About the application

Application number: 2024/92063	
What is the application for?:	Conversion and extension of dwelling to form 8 apartments (within a Conservation
Address of the site or building:	45a, St Helen's Gate, Almondbury, Huddersfield, HD4 6SG
Postcode:	WF7 7HF

User comments

Development Plan

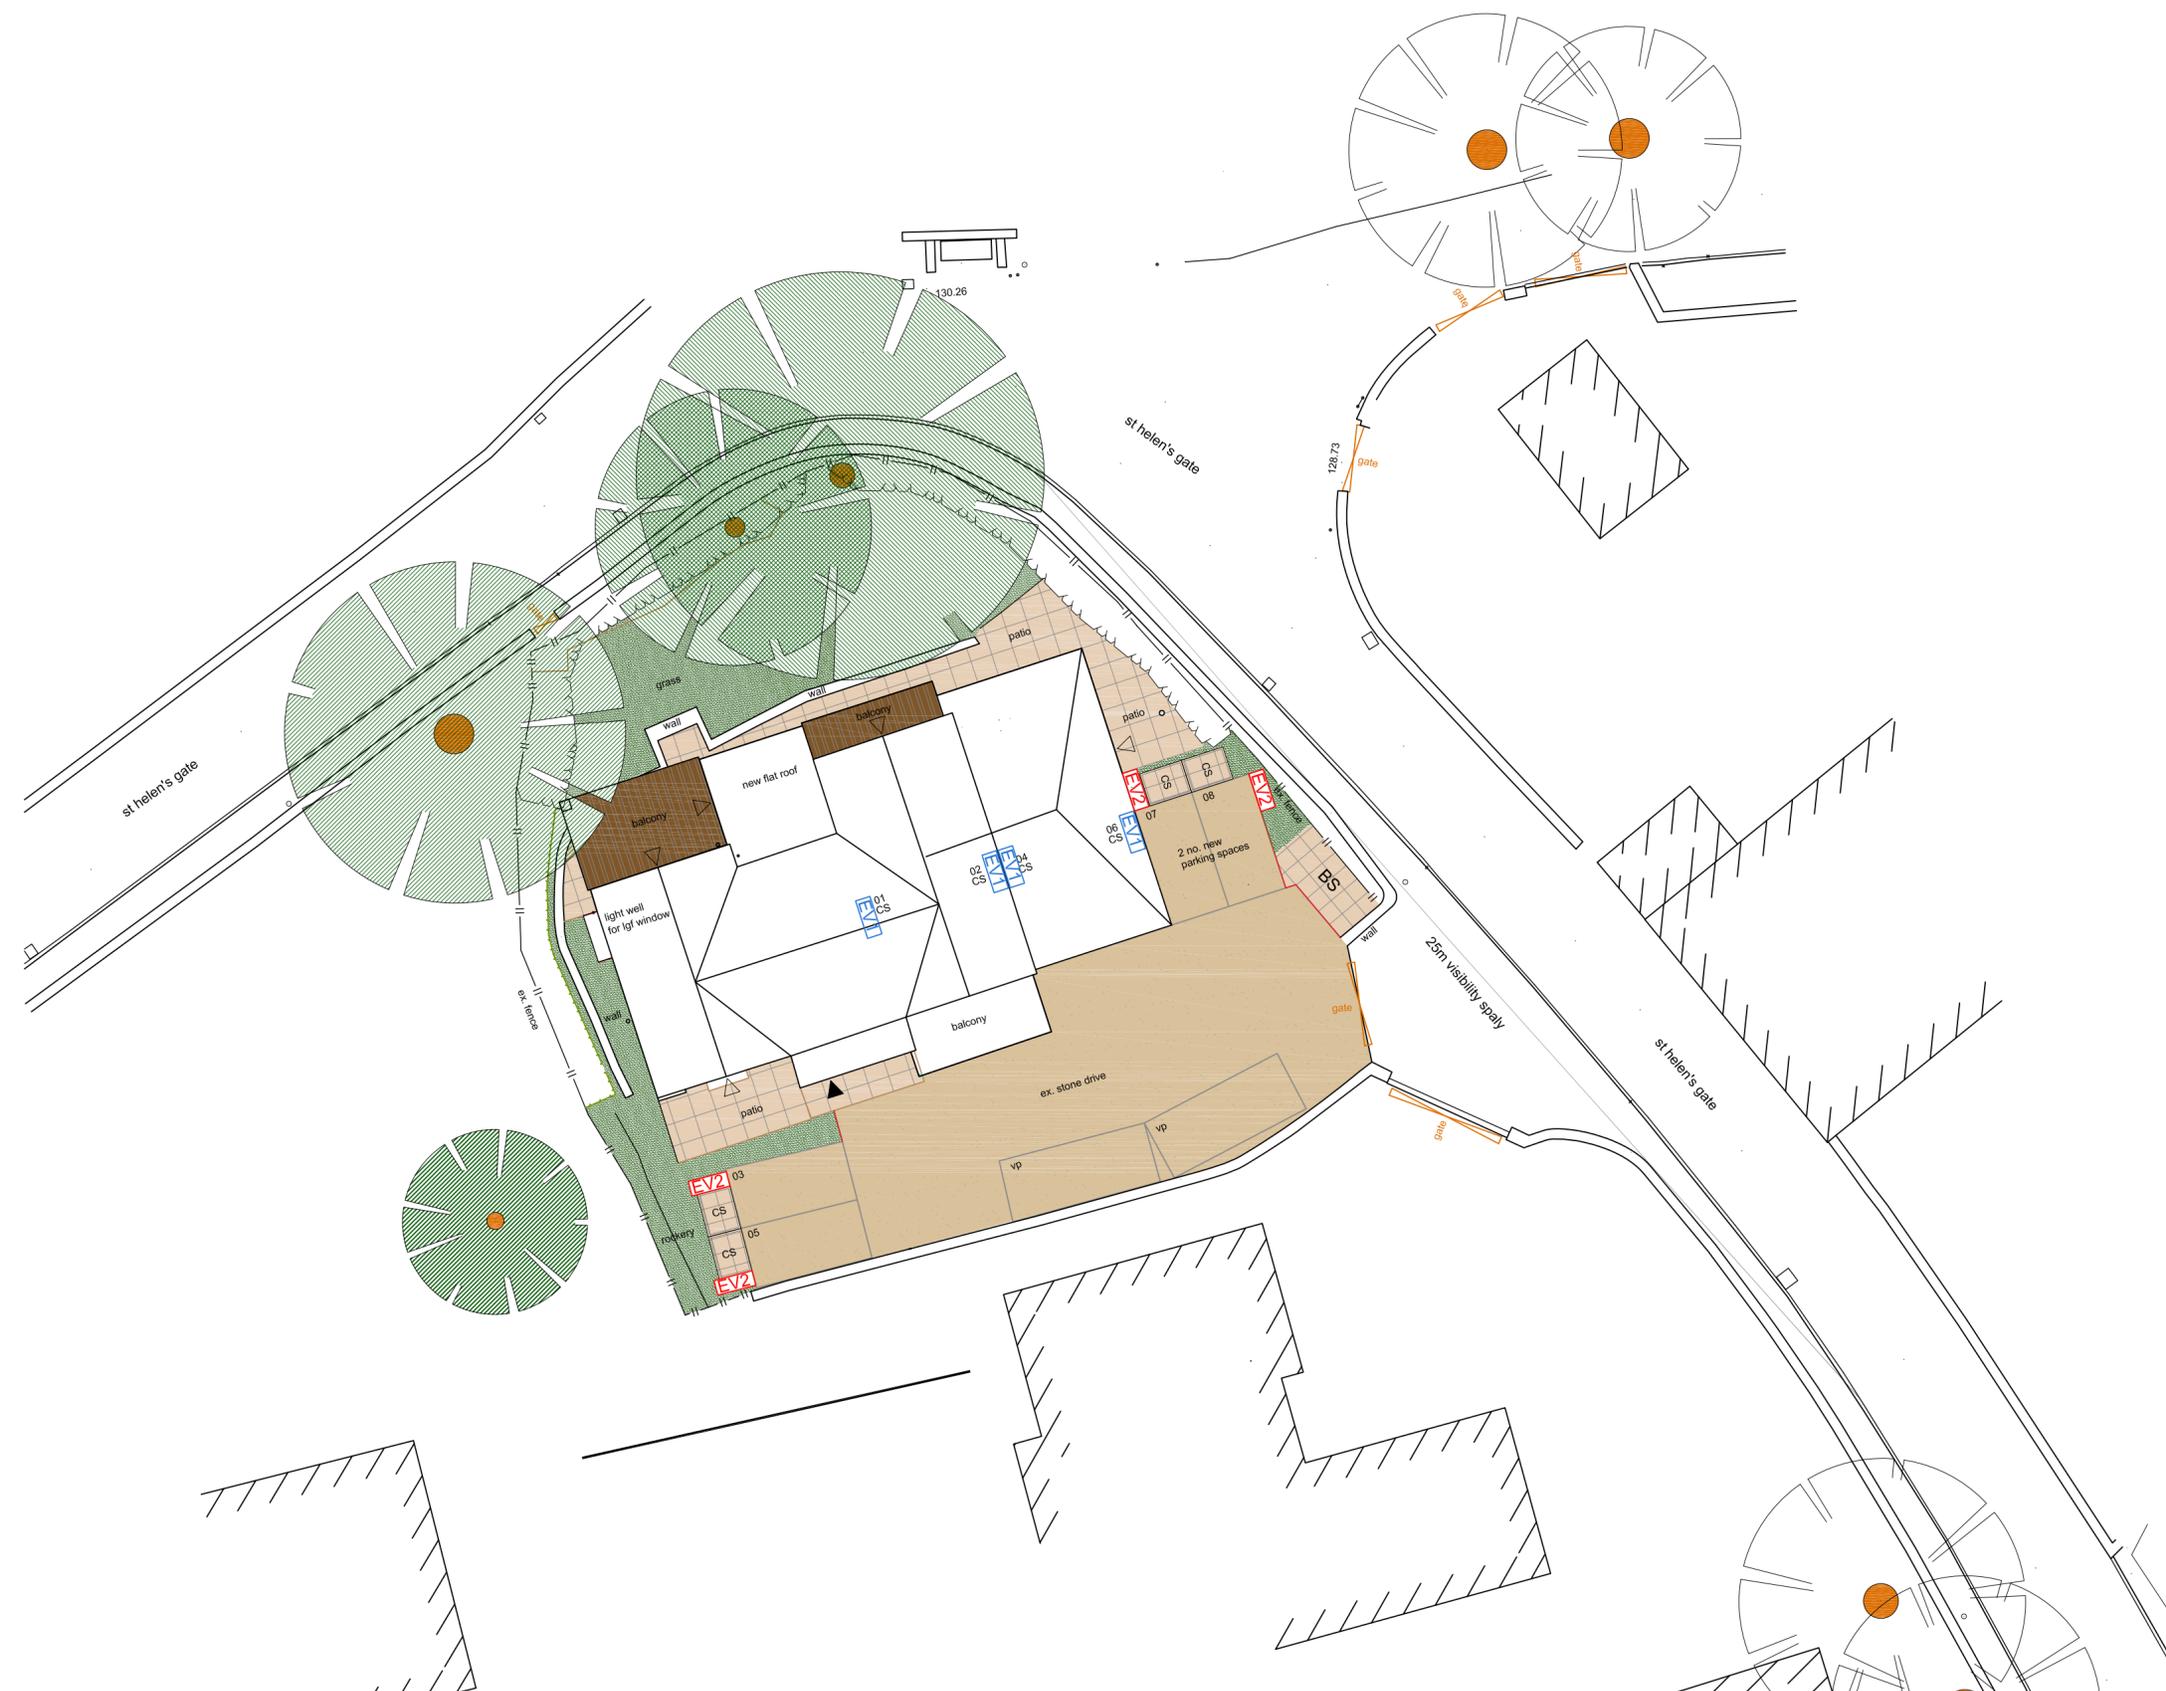
The proposed development significantly increases the parking spaces to 10 including two visitor spaces. The ability to practicably have 10 cars parked, whilst allowing for vehicles to manoeuvre, to exit forwards onto St Helens gate is overestimated. The swept volume of a medium car shown in the plans is only just room for a car to turn within the site. The likelihood of e.g. larger cars or vans needing to reverse onto St Helens Gate is high. St Helens Gate is narrow with poor visibility due to curvature of the road toward King James School and a 90 degree bend close to the property which makes reversing a vehicle onto St Helens Gate dangerous.

The provision of only 2 visitor spaces in the development between 8 properties would increase the likelihood of vehicles being parked on St Helens Gate, which is too narrow to cope with such parking. It is understood that there are plans by the Local Authority to paint double yellow lines near the property which would reduce any possible on-road parking further.
